Your ref:
Our ref: 21/00440/F
Please ask for: Mrs Rebecca Bush
Direct dial: 01553 616825
Direct fax: 01553 616652
E-mail: borough.planning@west-norfolk.gov.uk

Details: **Two storey extension to existing house at Compass Cottage Gong Lane
Burnham Overy Staithe King's Lynn Norfolk**

I have received a planning application as detailed above but cannot process it until I receive some more information:

BLOCK PLAN 1/500

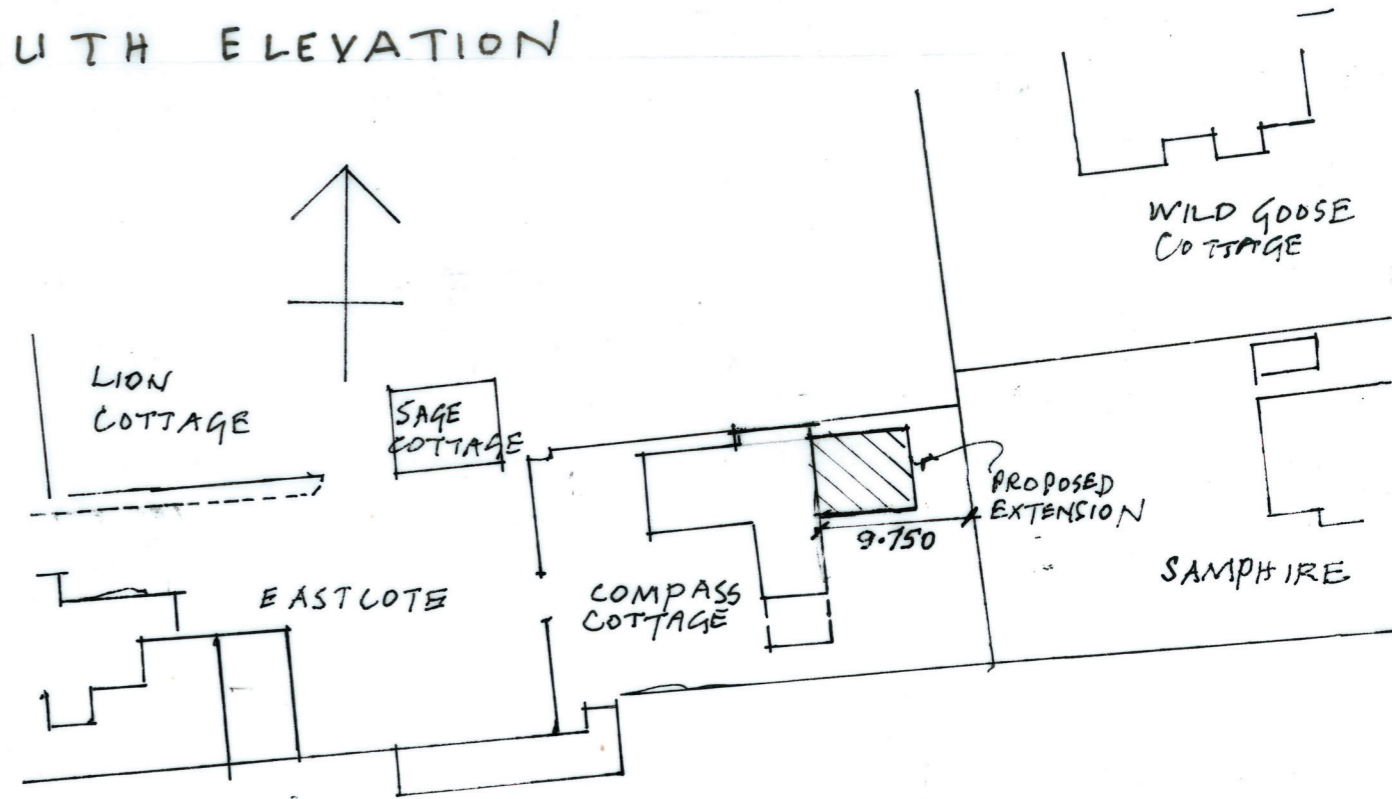
1. For some reason I can't print off your location plan, could you please send this again. Please note the red line on the location plan and block plan must match.
2. Unfortunately we will need existing elevations as well and floor plans to scale.
3. Please provide four drawings to a recognisable scale, showing existing and proposed site levels. If the site levels are to remain unchanged, please provide the drawings annotated as existing and proposed.
